FIVE ESTUARIES OFFSHORE WIND FARM DEVELOPMENT CONSENT ORDER

PINS REFERENCE EN010115

**DEADLINE 6: PORT OF LONDON
AUTHORITY'S COMMENTS ON SUBMISSIONS
RECEIVED AT DEADLINE 5**

Figure 2.2: Indicative operations summary for offshore construction activities.

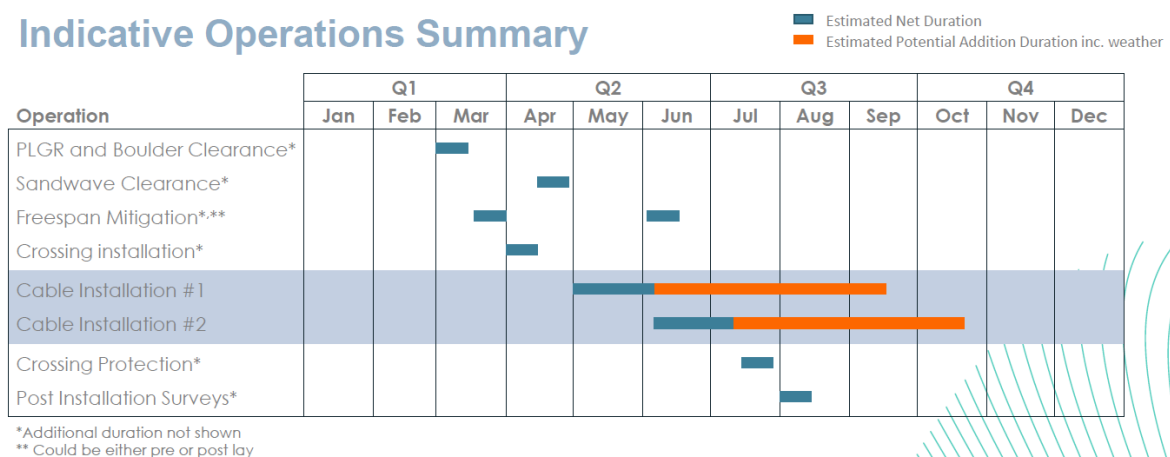
- (a) Restricted Ability to Manoeuvre ("**RAM**") vessels are the only ones being de-conflicted/restricted from working concurrently but other vessels listed in the indicative operations summary, which were previously considered as RAM, are now removed from the list in the project vessel activities tables and therefore could be used concurrently with other operations. It is not clear now which project vessels will fall under the concurrent working with other projects rule. For example, at paragraph 2.4.3 it states UXO clearance is RAM but in Table 3.2 they no longer are.

RAM vessels have prescribed rules which other vessels understand and comply with. There is concern that the various other operations/activities will be harder to manage as these vessels may consider themselves restricted without actually being so. For example, a boulder clearance vessel travelling at 1 knot may say it cannot move out of the way of a deep draft vessel due to its slow speed.

The Hazard and Operability ("**HAZOP**") workshop therefore should not just be for RAM vessels but should include all project vessels operations.
